# Technical Note: Gatwick Northern Runway Project: Critical Review of Air Quality Assessment

**Client:** CAGNE

**Reference:** APS\_S1043A\_A1-1

**Date Published:** 26 January 2024

Diagram 3.3.2: Model performance before and after adjustment, Brighton Road (airport) zone

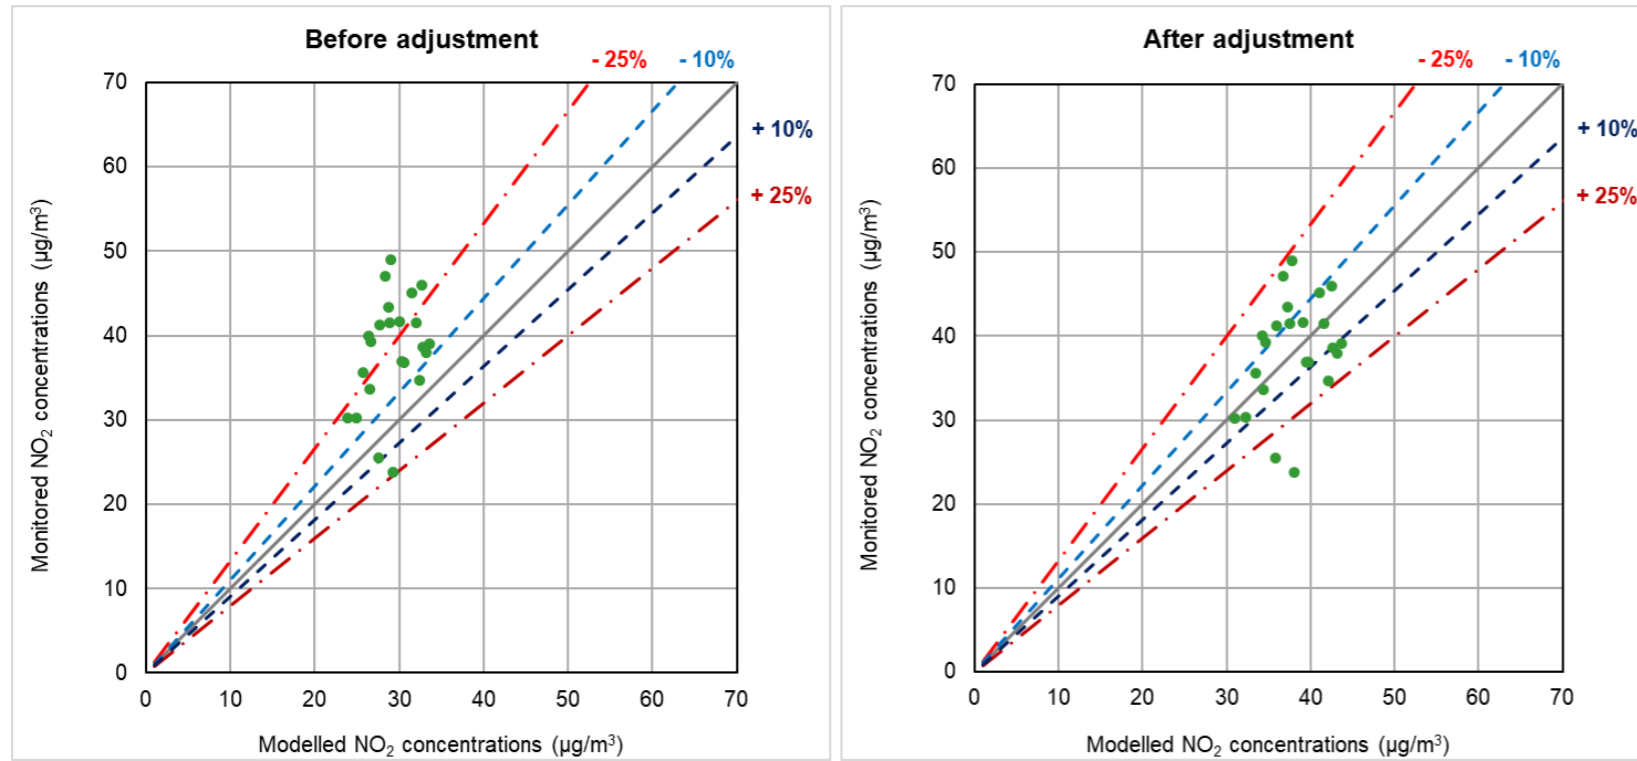
- 2.26. The correlation co-efficient is poor for the monitoring sites in London (0.5) and on Brighton Road (0.3). An ideal correlation is 1.0. The closer to zero the worst the correlation. For environmental parameters a correlation of 1 is not expected but 0.3 and 0.5 both show a poor correlation. This means there is a widespread in the data points, and that the model is not representing reality well.

- 2.28. The root mean square error (RMSE) is also a measure of the spread of the data. For Brighton Road it was  $6.1 \mu\text{g}/\text{m}^3$ , Croydon Park Lane  $9.7 \mu\text{g}/\text{m}^3$  Storrington  $6.2 \mu\text{g}/\text{m}^3$ , and between  $5 \mu\text{g}/\text{m}^3$  and  $6 \mu\text{g}/\text{m}^3$  at Hazelwick Roundabout (an air quality management area (AQMA)) ( $5.0 \mu\text{g}/\text{m}^3$ ), M23 and M25 ( $5.0 \mu\text{g}/\text{m}^3$ ), and London ( $5.7 \mu\text{g}/\text{m}^3$ ).

Diagram 3.3.4: Model performance before and after adjustment, Crawley zone

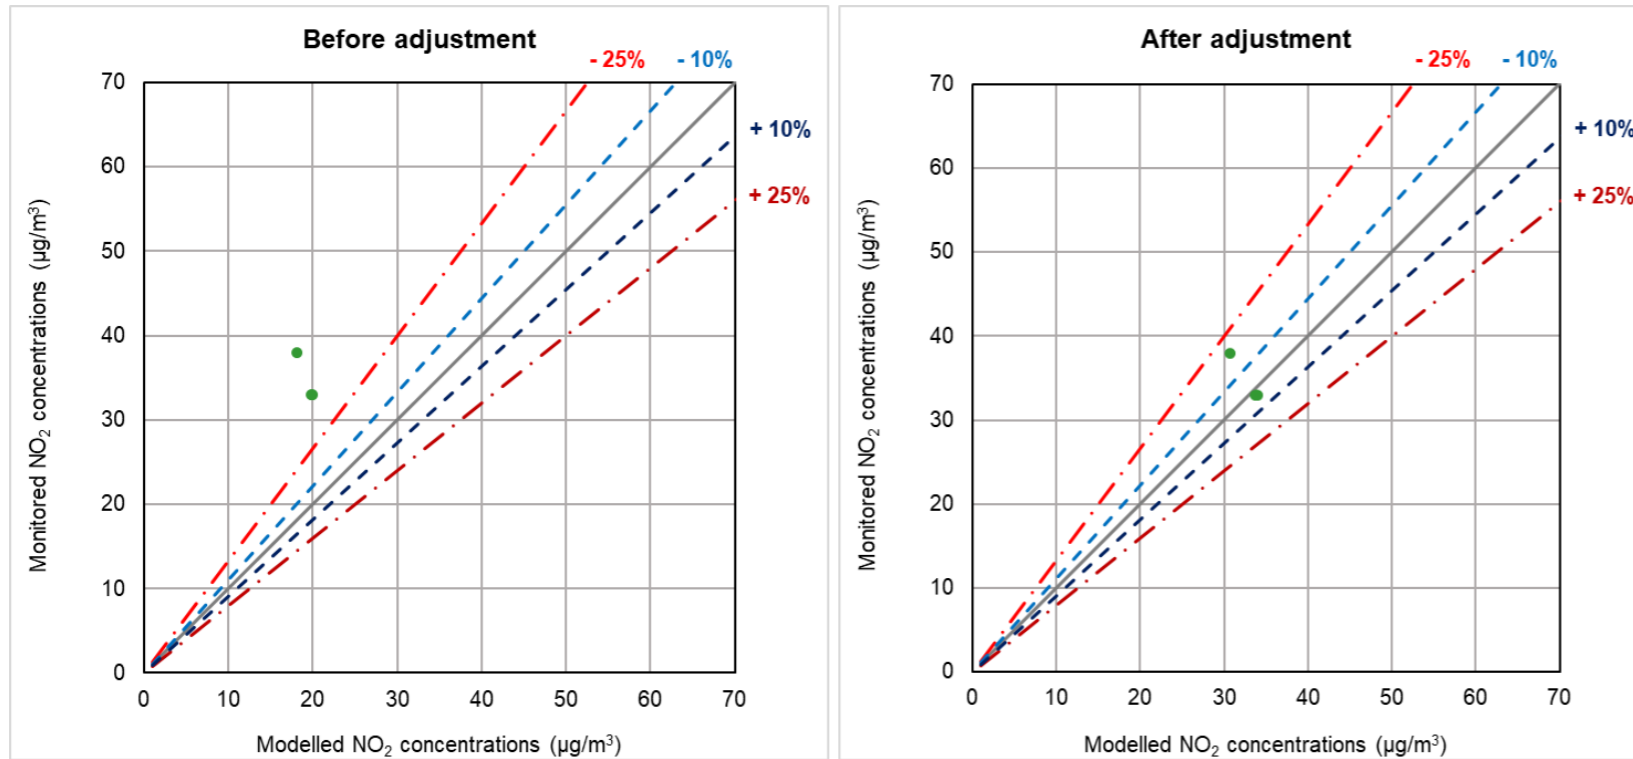
- 2.27. The correlation co-efficient was negative for three of the zones (Crawley, Croydon Park Lane and Merstham). In lay terms this means that as the measured concentrations decrease the modelled concentration increase. This is obviously nonsensical, and its cause should have been investigated. It suggests poor performance of the model.

Diagram 3.3.5: Model performance before and after adjustment, Croydon (Park Lane) zone

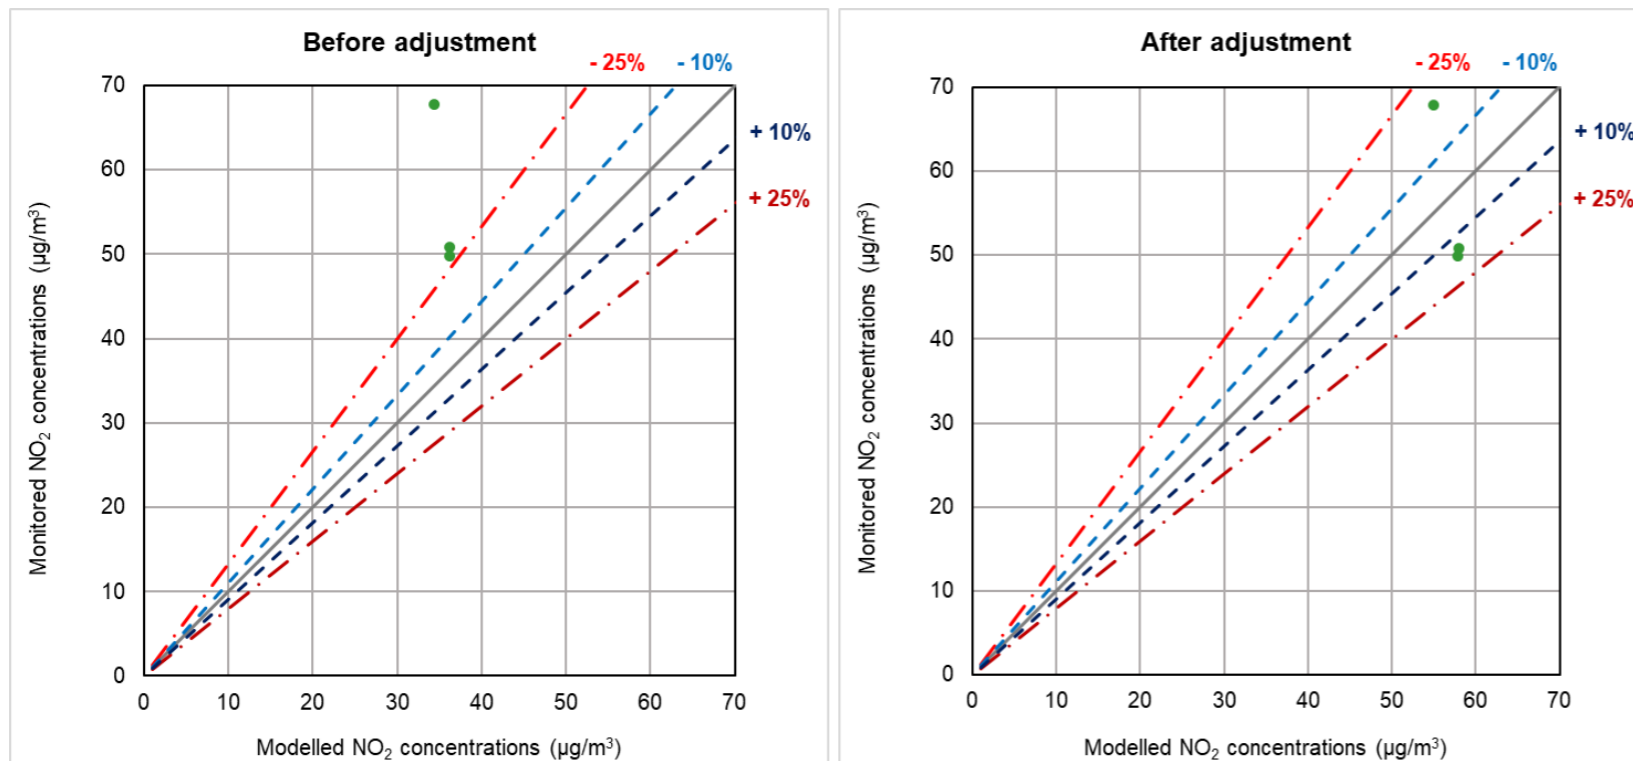
- 2.29. In lay terms this means that the accuracy of the model, for example in the Croydon Park Lane zone is  $+9.7 \mu\text{g}/\text{m}^3$  (almost 25% of the objective). At best it is  $+2.9 \mu\text{g}/\text{m}^3$  in the Cowfold zone. This is very important when comparing the model results with a fixed concentration (e.g. an air quality standard). It is also essential that any predicted concentrations from the model therefore accounts for this range of uncertainty.
